General Permit SWPPP Inspection

Site Name:	Phoenix Apartment Building Phoenix Apartment Building	Inspector:	Marcos Valadez
Permit #:	NMR10047E	Inspection Frequency:	Bi-weekly
Date of Visit:	Aug 18, 2022, 11:58:41 AM	Last Rain Event Saturday, August 13, 2022, 0.0"	Last Precipitation Thursday, August 18, 2022, 0.01" 48h Forecast 84% Chance of Rain

TEMPORARY EROSION AND SEDIMENT CONTROL PLAN

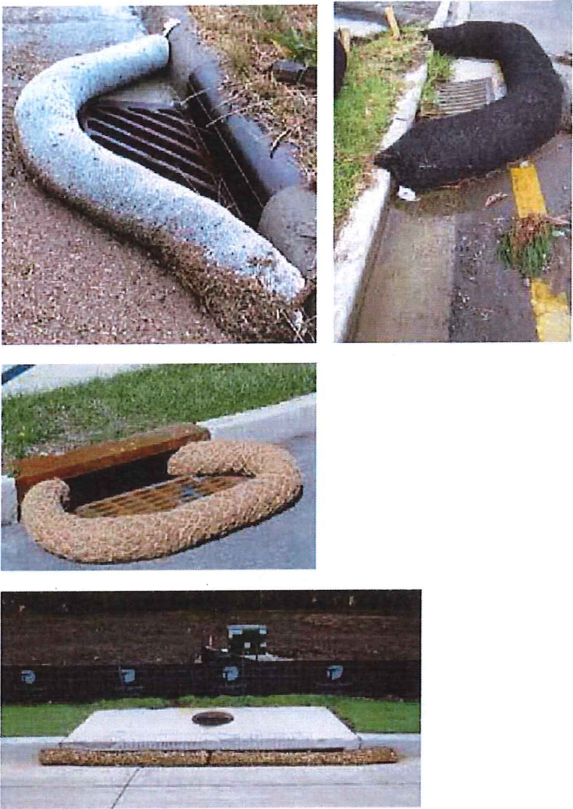
Fabric attached to the fence needs to be repaired where needed. The East side has been repaired.

The east side has been repaired and sidewalk has been swept. Swppp book is on site Job trailer See the action items.
